From: [REDACTED]
Sent: 05 October 2017 02:48
To: Planning
Cc: [REDACTED]
Subject: FP/177/17/OUT - Rear of 9 Downview Road Felpham PO22 8HG - OBJECT

RE: Application FP/177/17/OUT - Rear of 9 Downview Road Felpham PO22 8HG

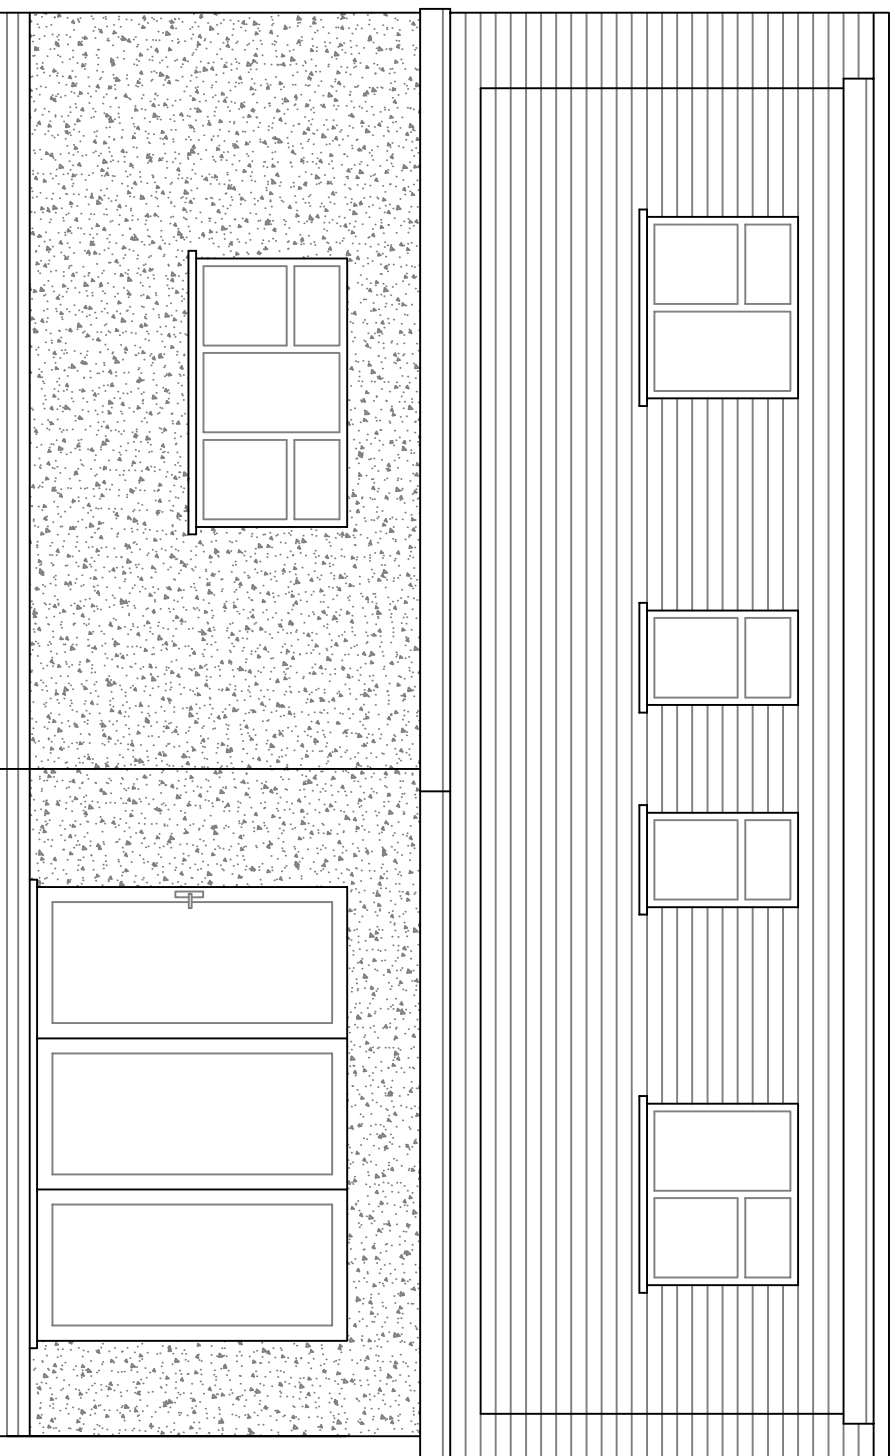
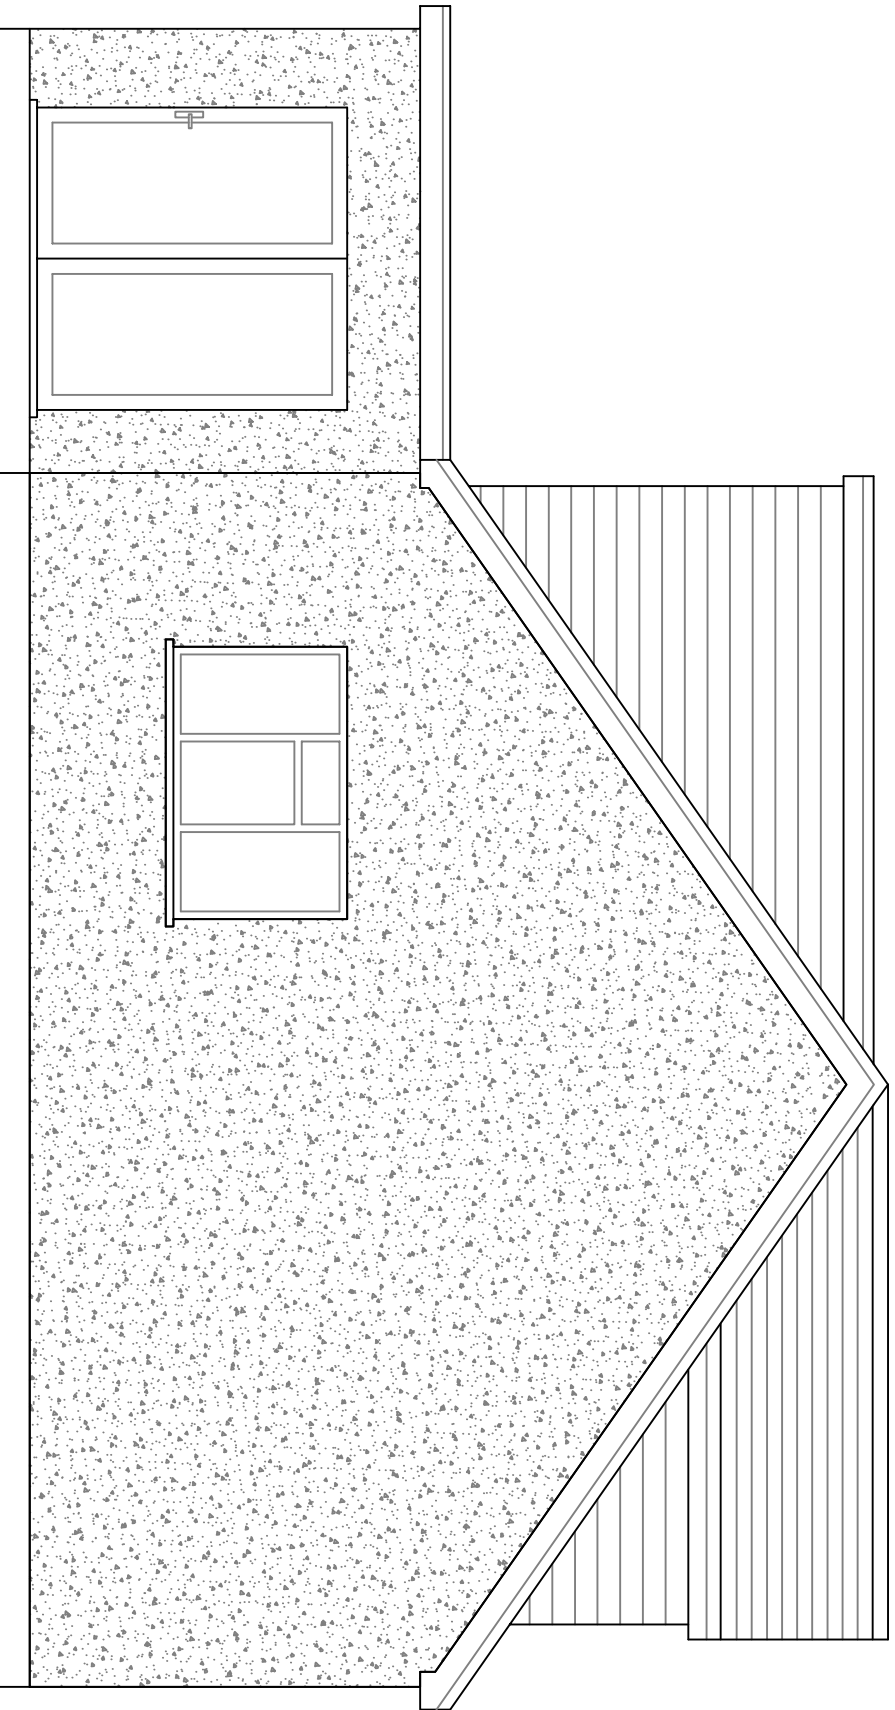
There are discrepancies on the application plans and elevations with respect to the house being called a bungalow, let alone no height measurements, given it’s for a new two-storey - three-bedroom house.

The new two-storey house would be overbearing to my property, especially one of its walls will be only 150cm from my fence. This wall is ground to top of roof apex height. The design has not attempted to pitch this wall away from my land, so not attempting to reduce its overbearing nature.

The submitted plan is only for outline purposes, it has no real detail or clear measurements of actual size and height. It concerns me as I have no ability to really understand how big a mass and how overbearing it would be.
